**August 26, 2009**

**DRB Comments**

**PROJECT # 1004241**

**RE: Lot 7-A, Block C, Highland Addition South**

**PLAT OF SURVEY
FOR
BROADWAY VISTAS DEVELOPMENT
BEING A REPLAT ON
LOT 7-A, BLOCK C
HIGHLAND ADDITION SOUTH
CITY OF ALBUQUERQUE
BERNALILLO COUNTY, NEW MEXICO
NOVEMBER, 2008**

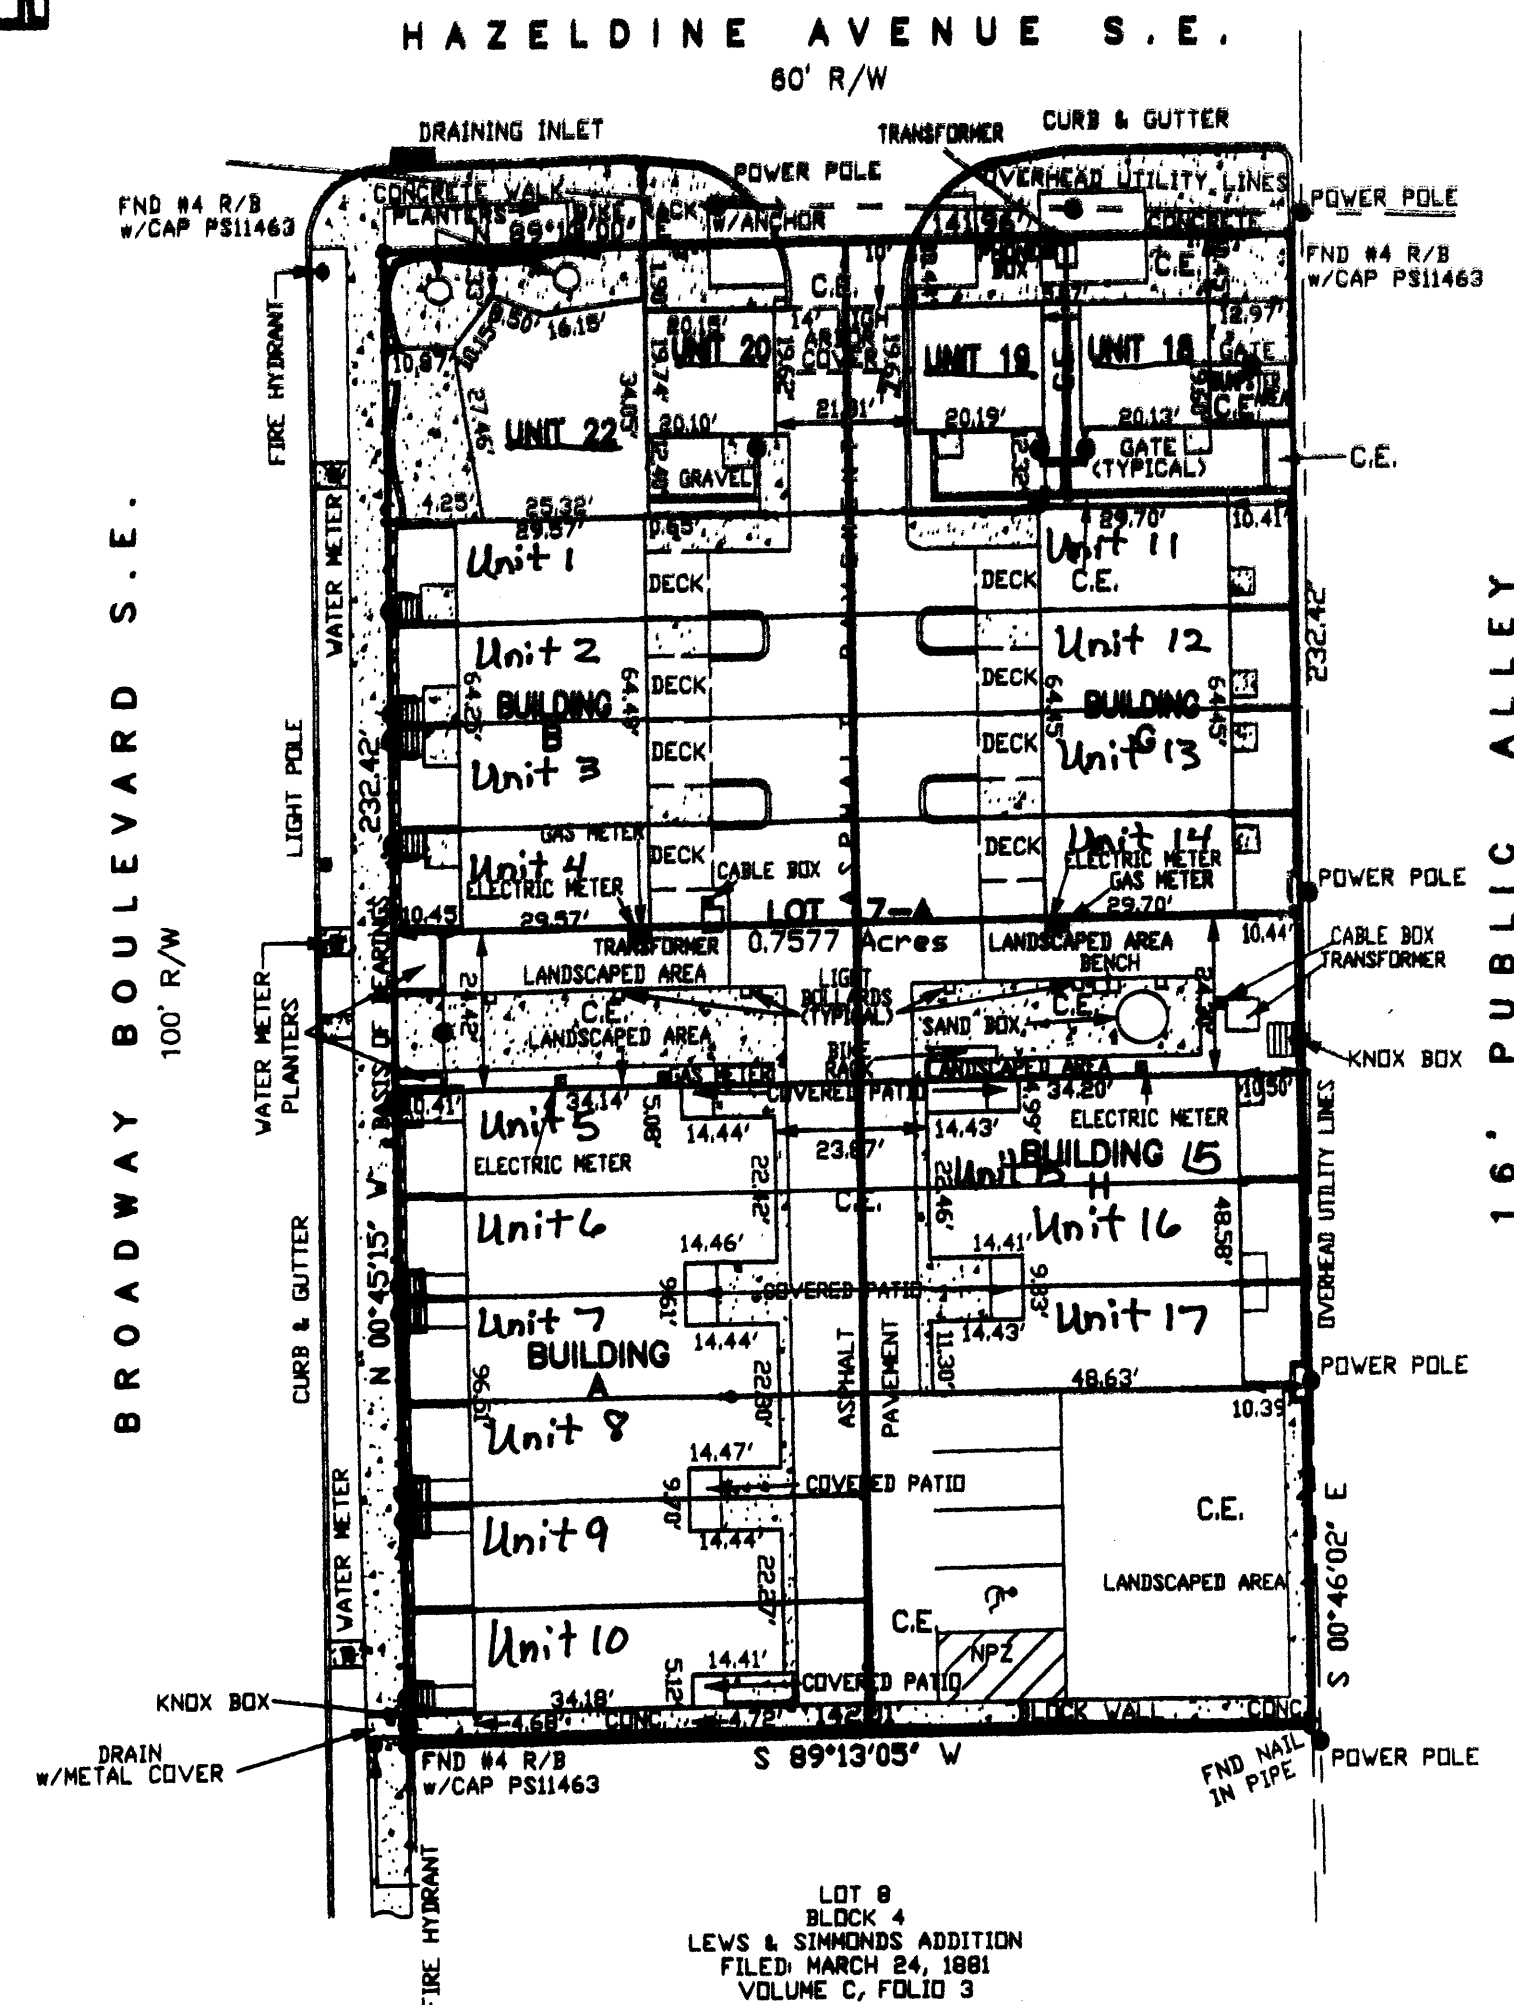
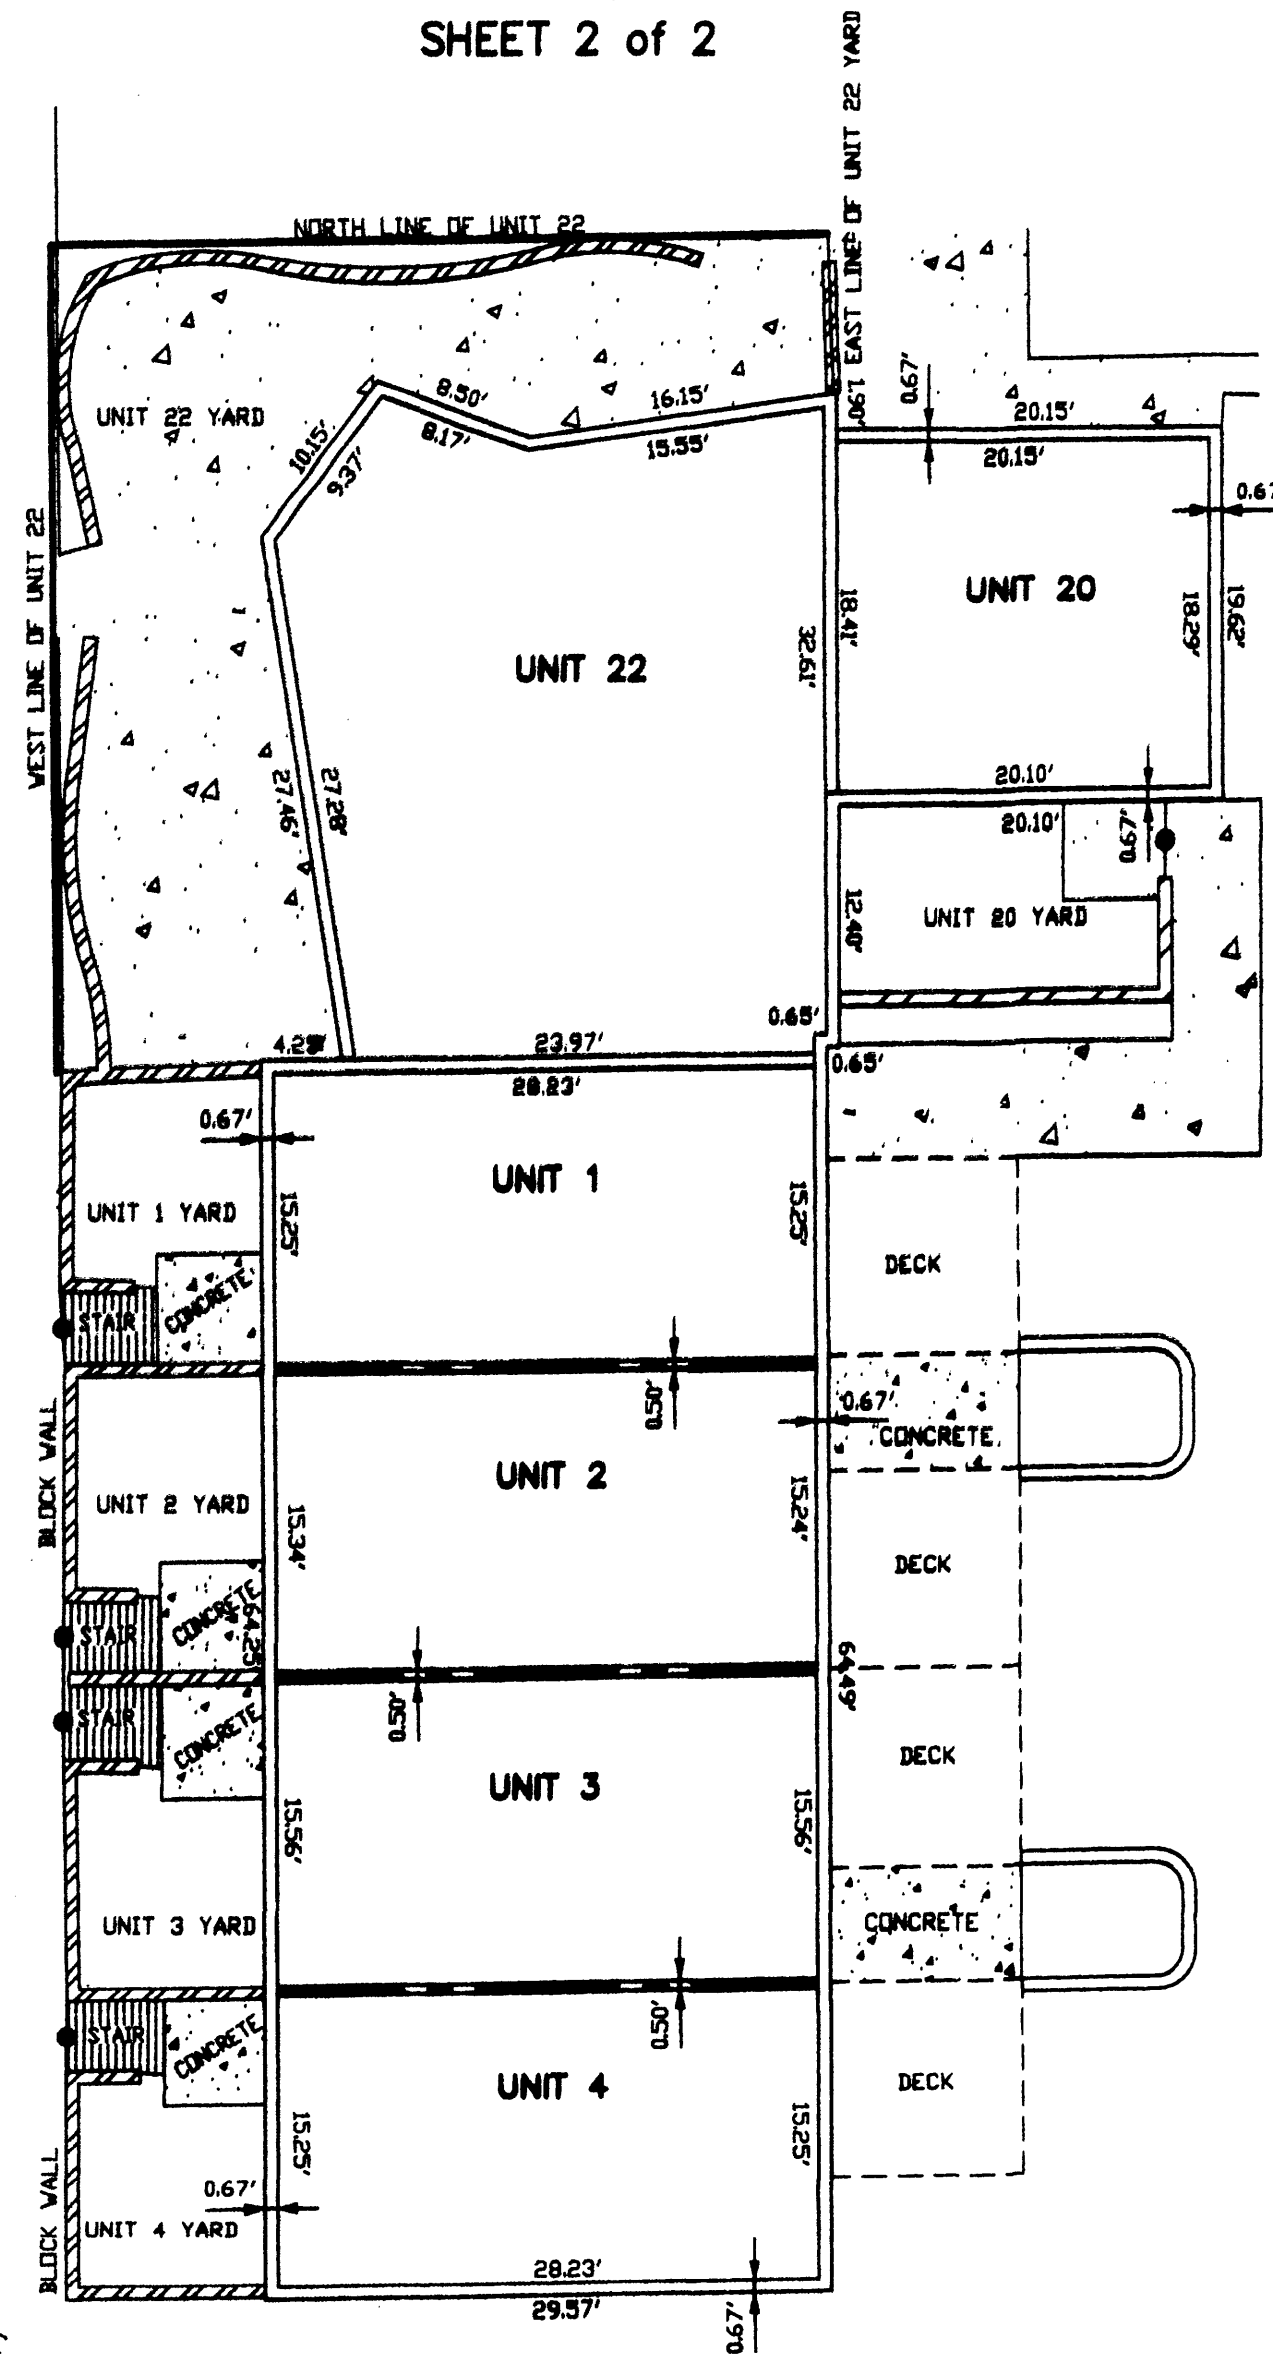
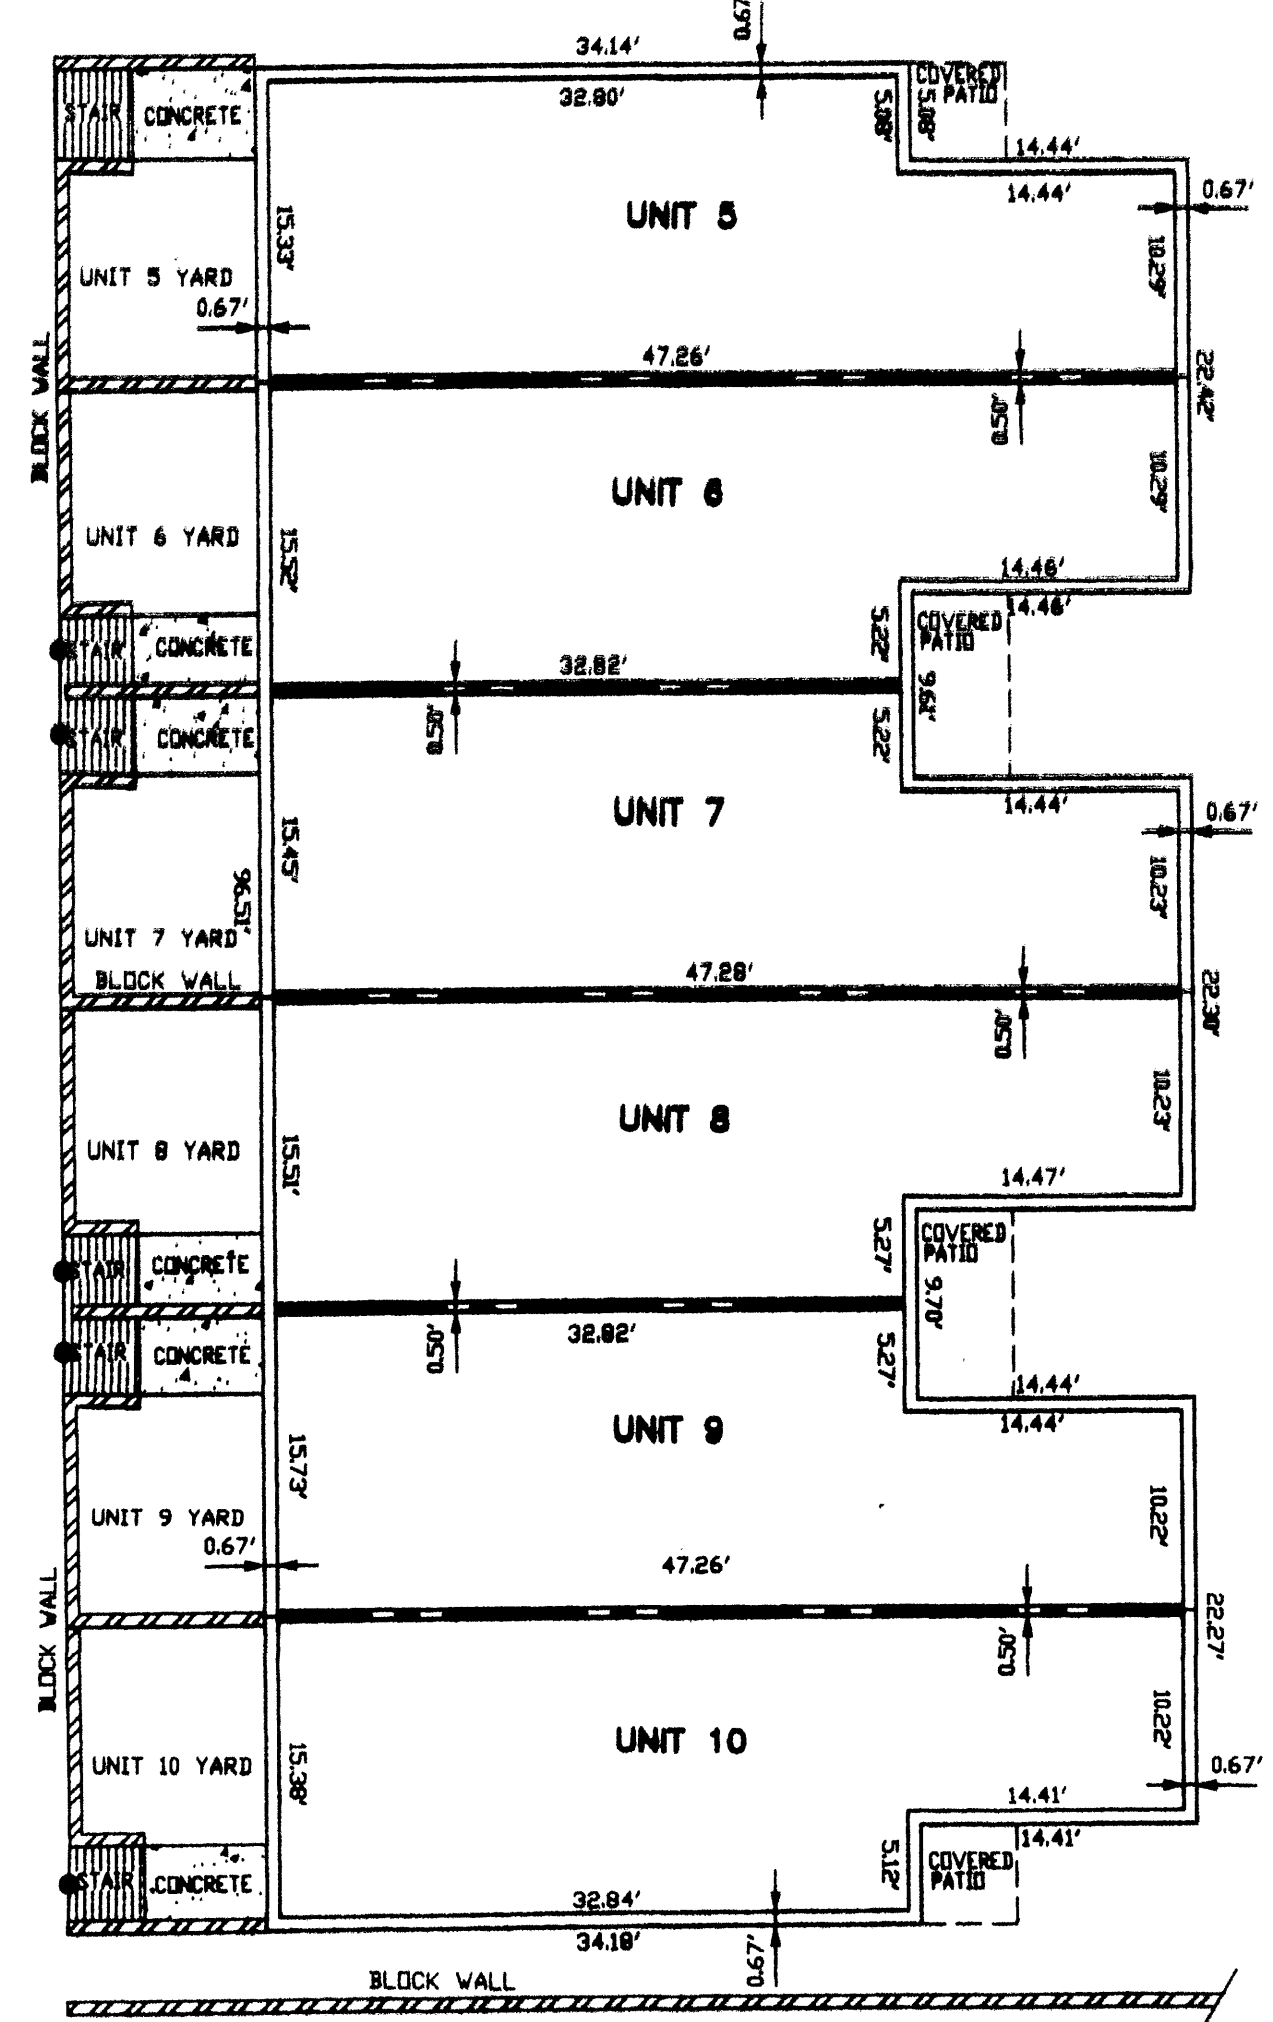
The site is zoned SU-2/ NCR and is within the South Broadway Sector Development Plan area; R-2 regulations generally apply for residential development, which refers to the RT zone for townhouses with a minimum 22 foot lot width and 2,200 square foot lot area. The proposed townhouse subdivision would require variances from both width and area requirements prior to application for subdivision approval. Additionally, common building walls would need to be certified to meet building code requirements for attached dwellings prior to application. Finally, "Landscaped Areas" might be more appropriately platted as easements over adjacent lots.

This would be classified a major subdivision by the Subdivision Ordinance, and would require an advertised public hearing by the Development Review Board.
